November 20, 2015

SUBJECT: Permit Modification Request for Section 404 Individual Permit and Section 401 Individual Water Quality Certification for the US-74 Monroe Connector/Bypass in Union and Mecklenburg Counties. STIP R-3329 and STIP R-2559, Division 10, Debit WBS Element 34533.1.TA1 in the amount of \$570.

Reference: US Army Corps of Engineers (USACE) 404 Permit issued May 8, 2015; Action ID: SAW-2009-00876
NC Division of Water Resources (NCDWR) 401 Water Quality Certification Permit issued March 6, 2015; NCDWR Project No. 02-0672 V3

PROJECT REFERENCE NO. <i>R-3329 / R-2559</i>		SHEET NO. <i>66</i>	
RW SHEET NO.			
ROADWAY DESIGN ENGINEER		HYDRAULICS ENGINEER	
<i>REVISED 11/9/2015</i> <i>PERMIT DRAWING</i> <i>SHEET 229 OF 267</i>

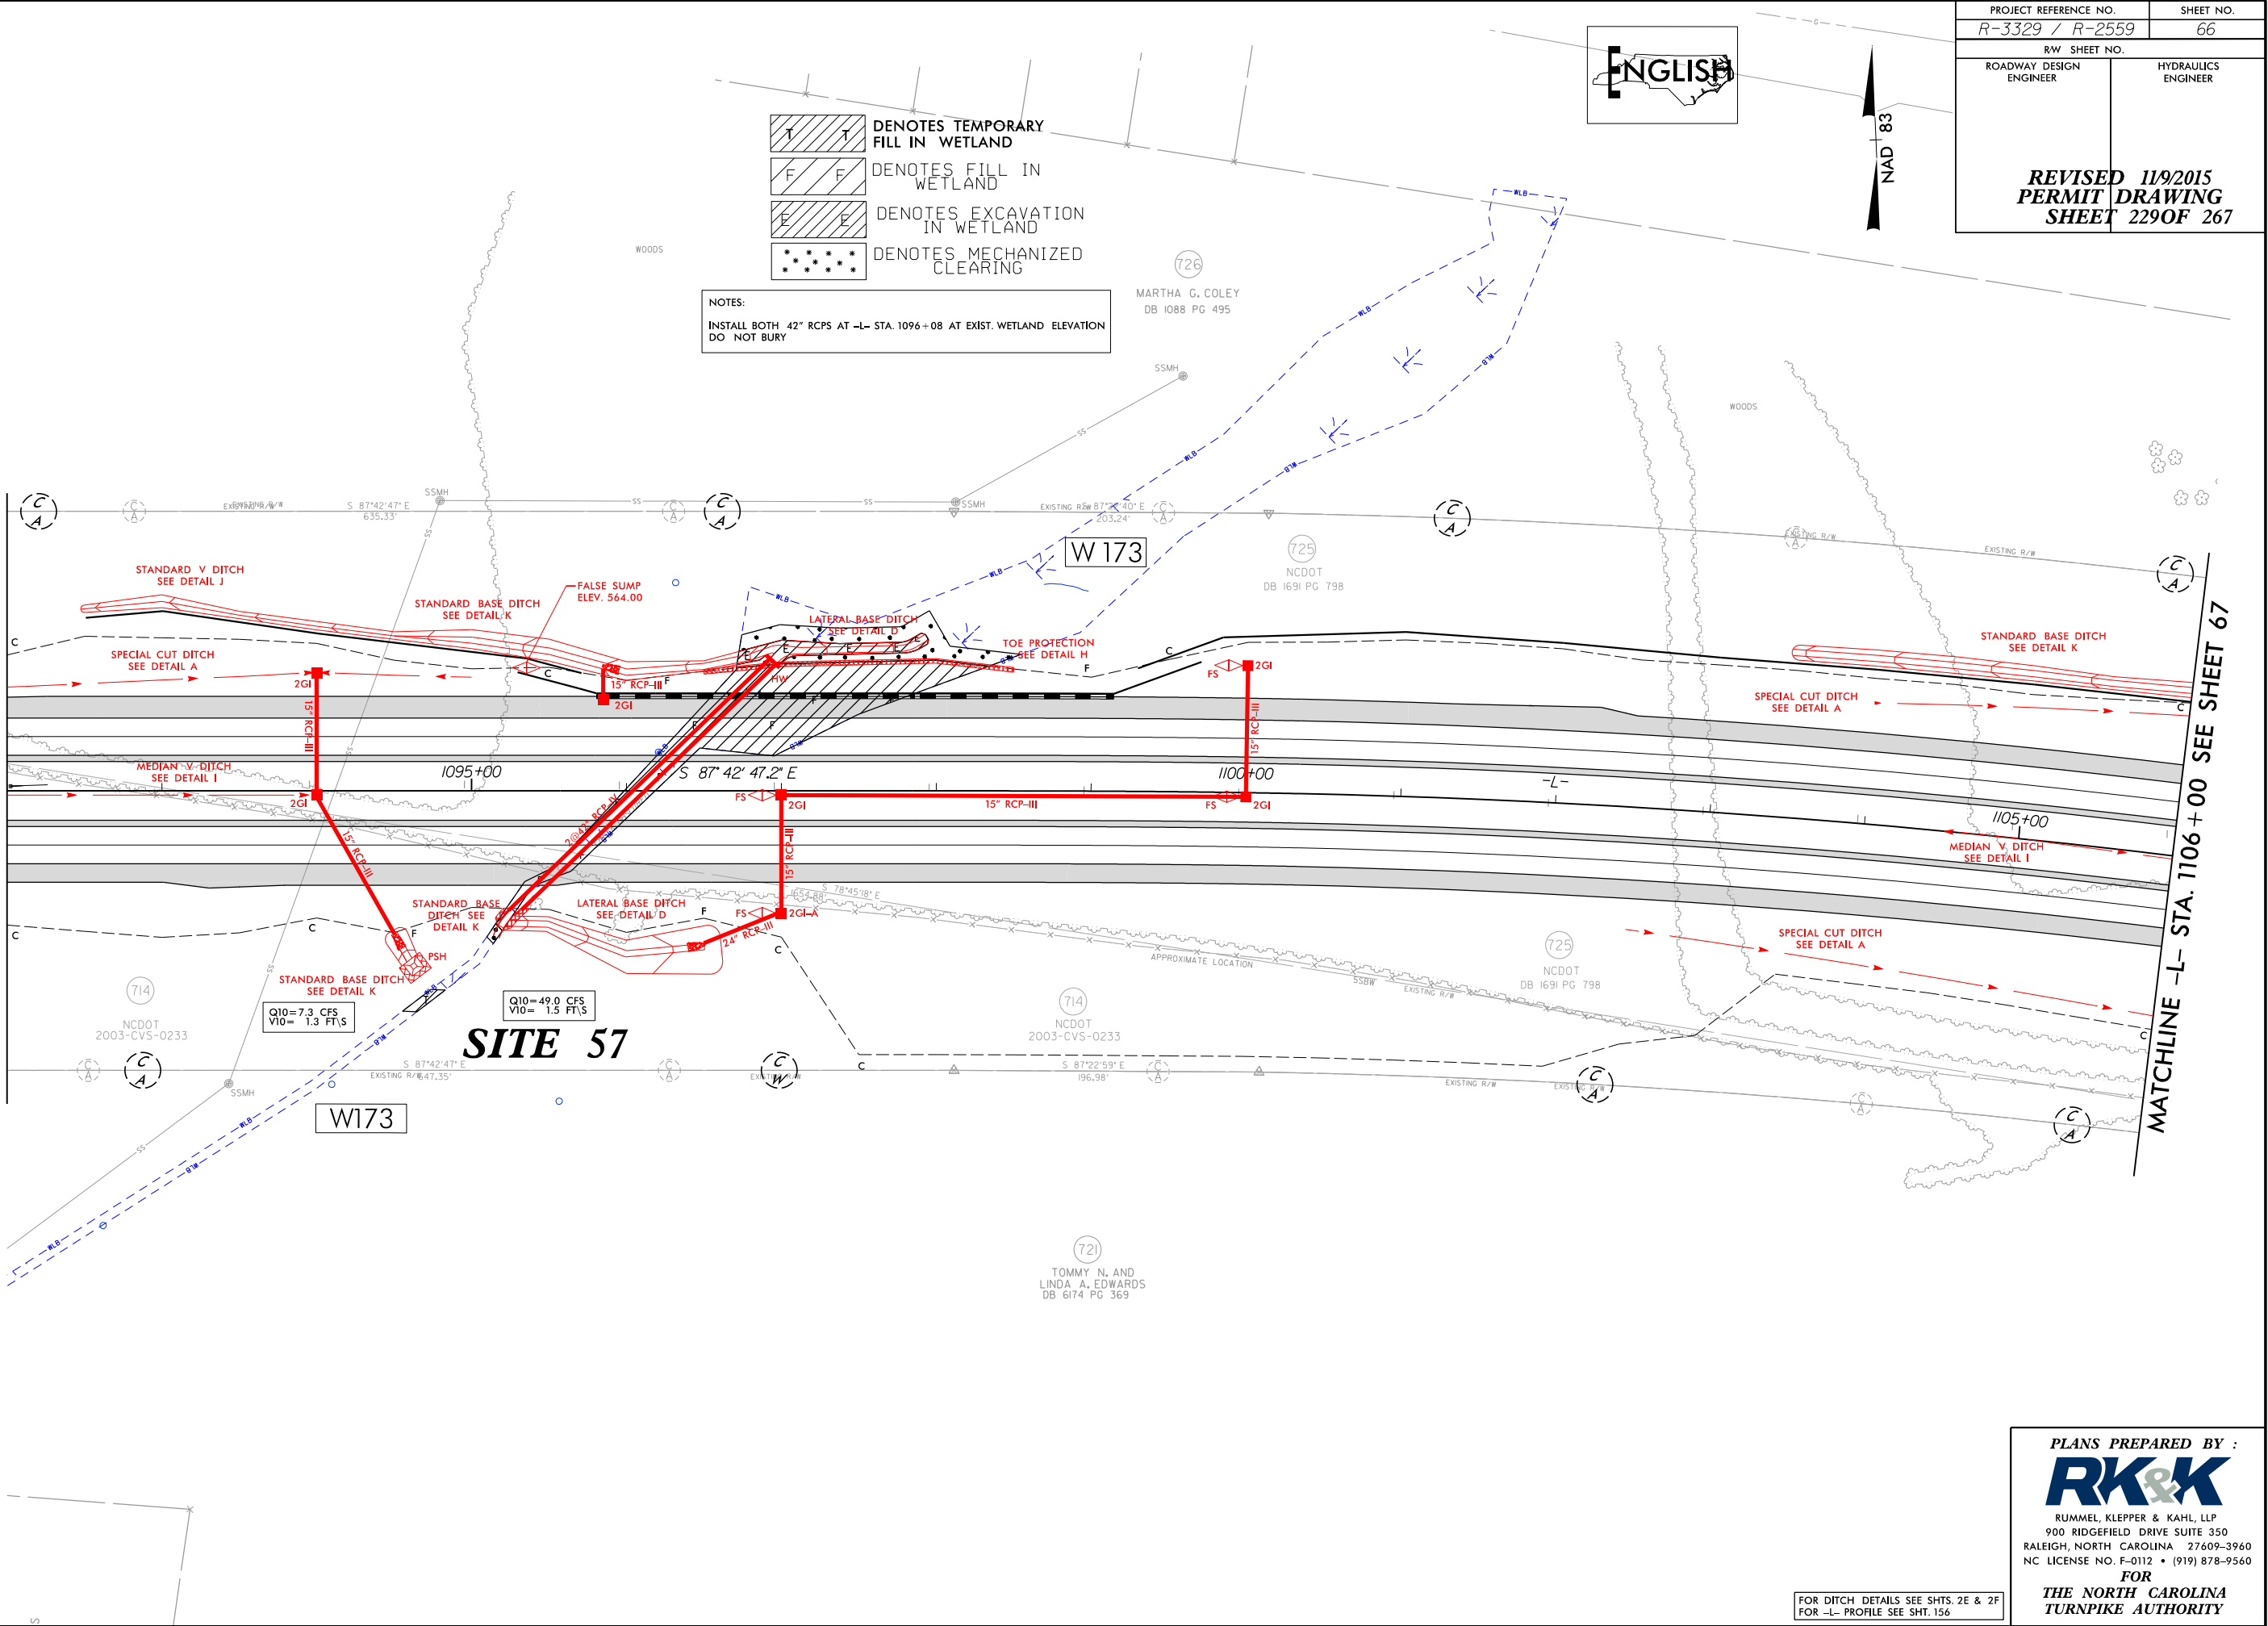
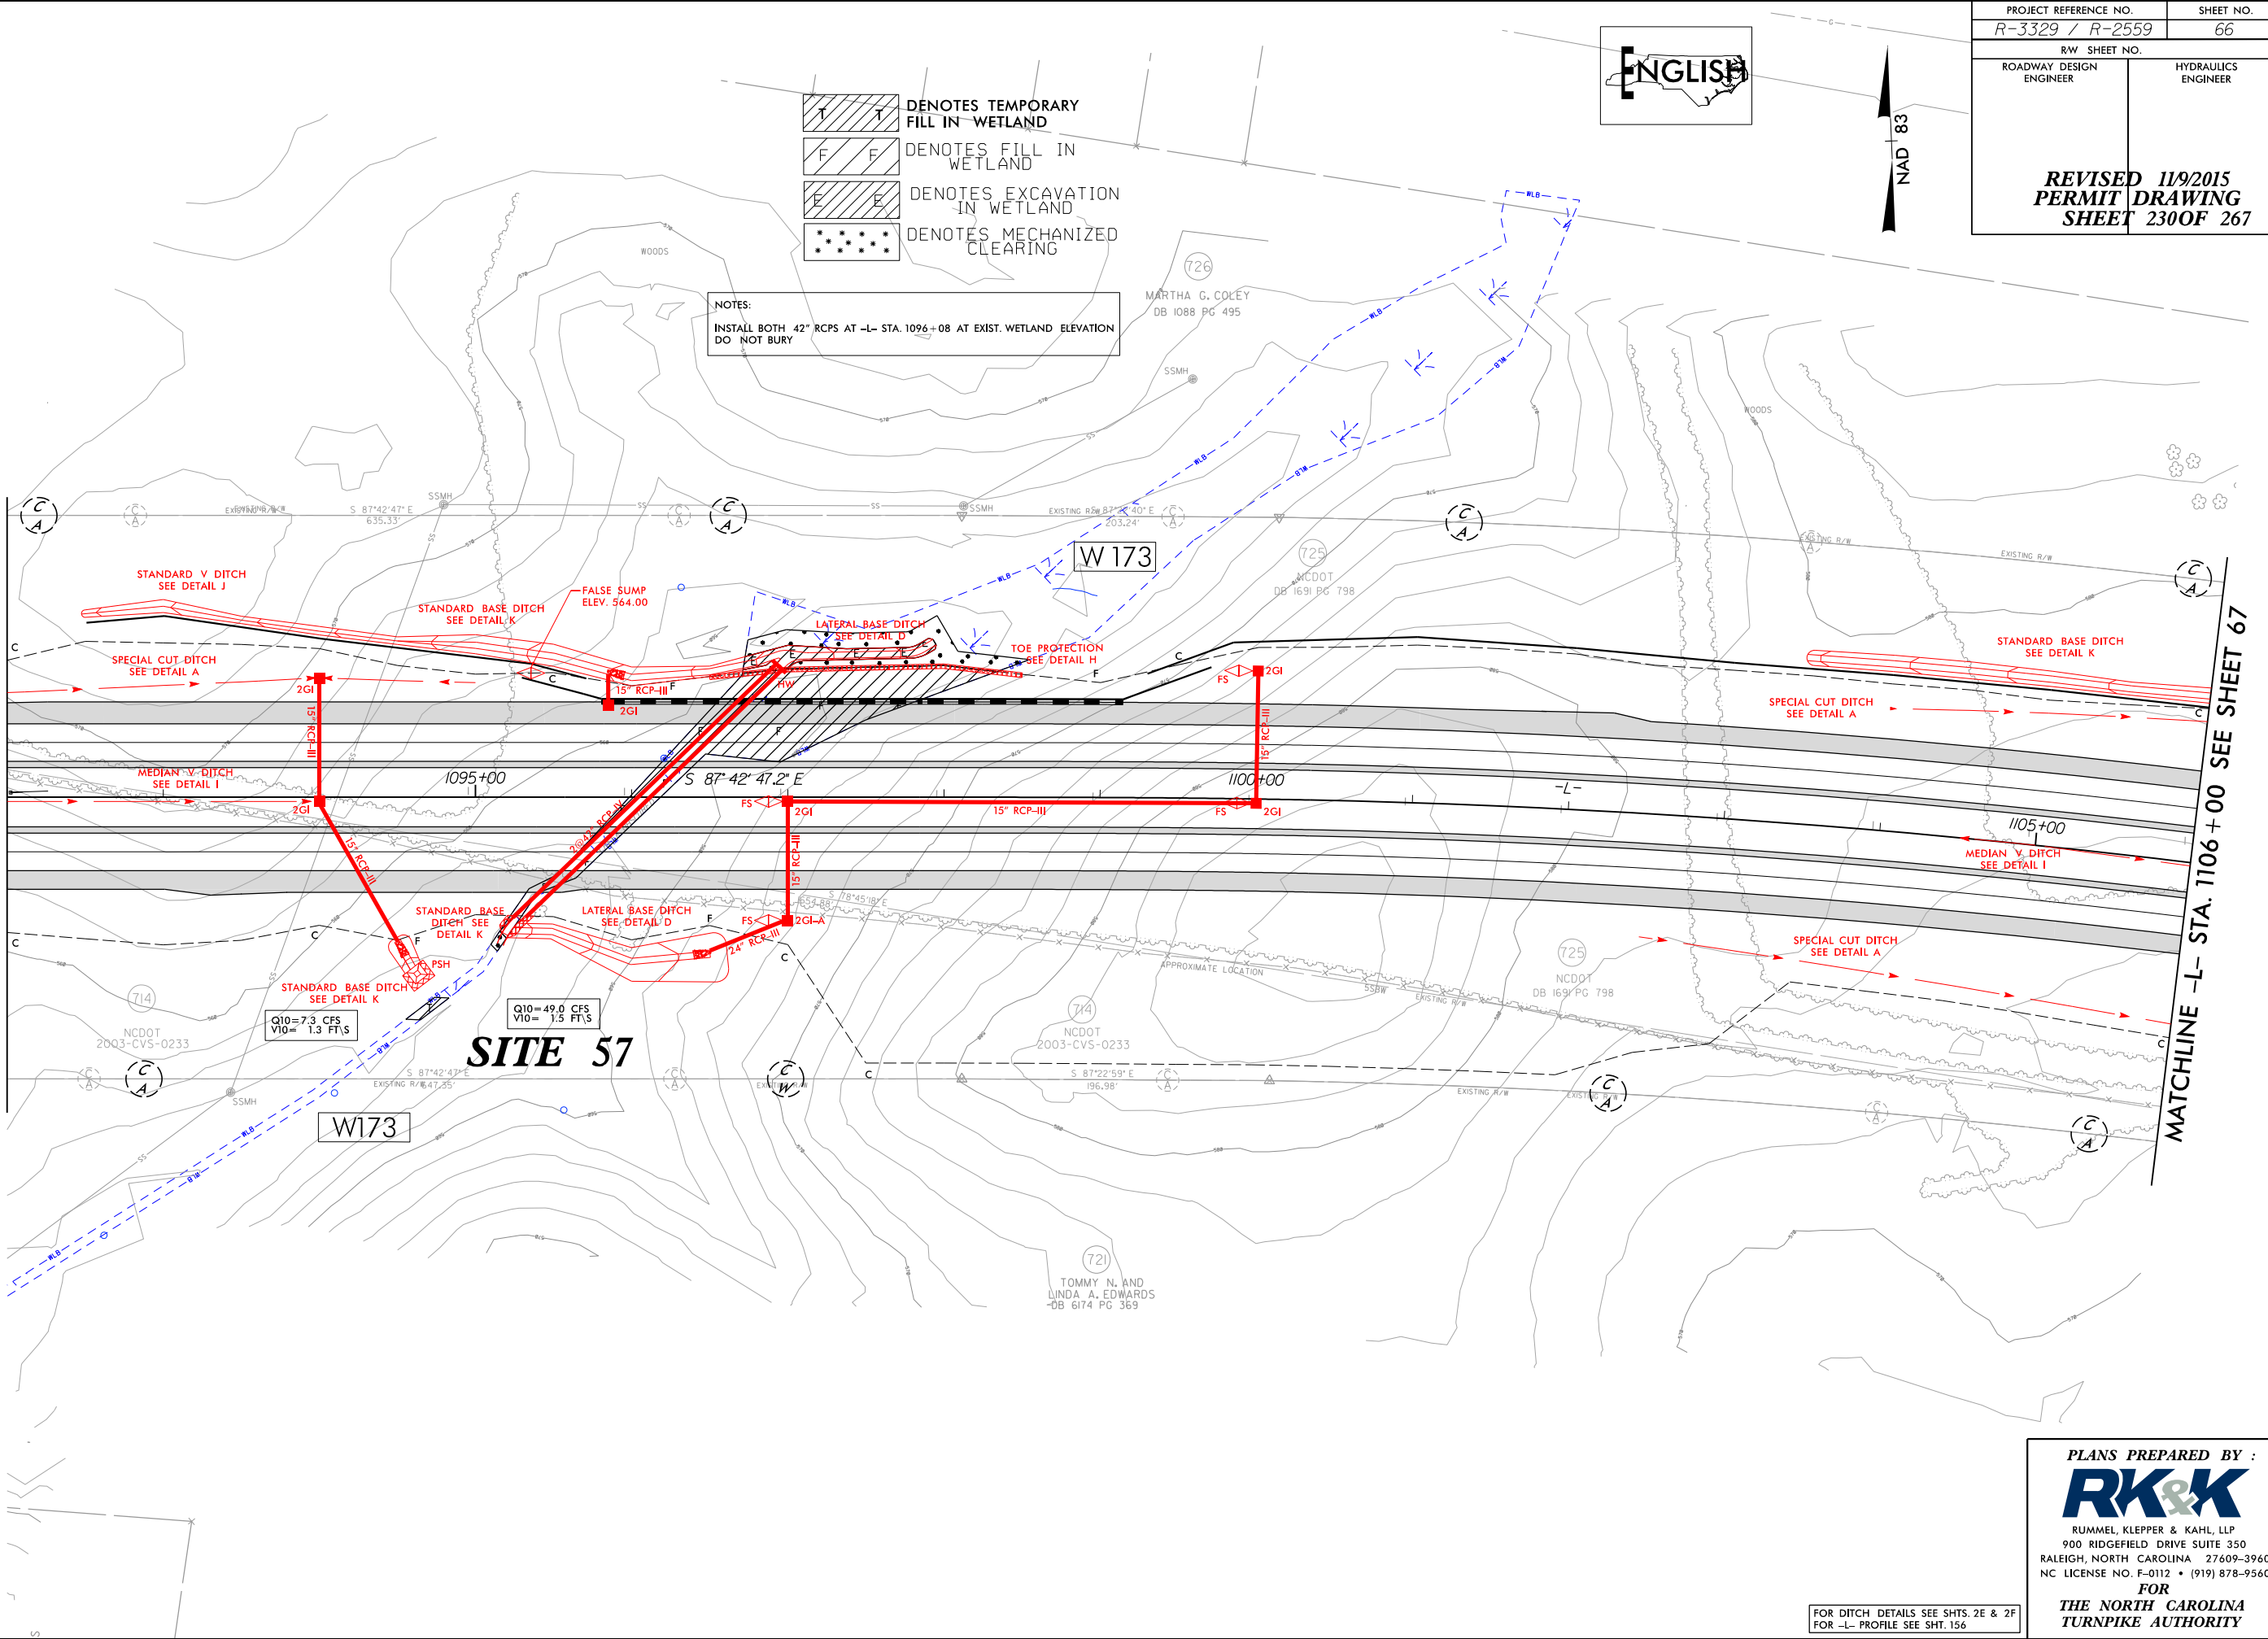
Permit Site 57 (Revised Permit Drawings 229 and 230 of 267).

As you are aware from our correspondence on August 21, 2015, prior to the start of construction, environmental staff re-flagged jurisdictional areas for crews to install orange construction "avoidance" fencing. At the time, Site 57 was an active pasture. At some point between flagging and fencing installation, the flagging was removed. This precipitated several other events eventually resulting in the fill of a section of the Site 57 wetland, not previously authorized for fill.

This resulted in approximately 500 ft² (<0.01 acre) of permanent wetland impacts.

Upon discovery and reporting of the error, the contractor was prepared to remove the fill and return the site to pre-construction conditions. However, after further discussion with Division 10 and the Natural Environment Section, this impact allows for an expedited construction of the adjacent permanent pipe crossing. With this consideration, it was agreed to leave the temporary fill in place, expedite construction of the pipes, and remove the fill and return the area to its natural state.
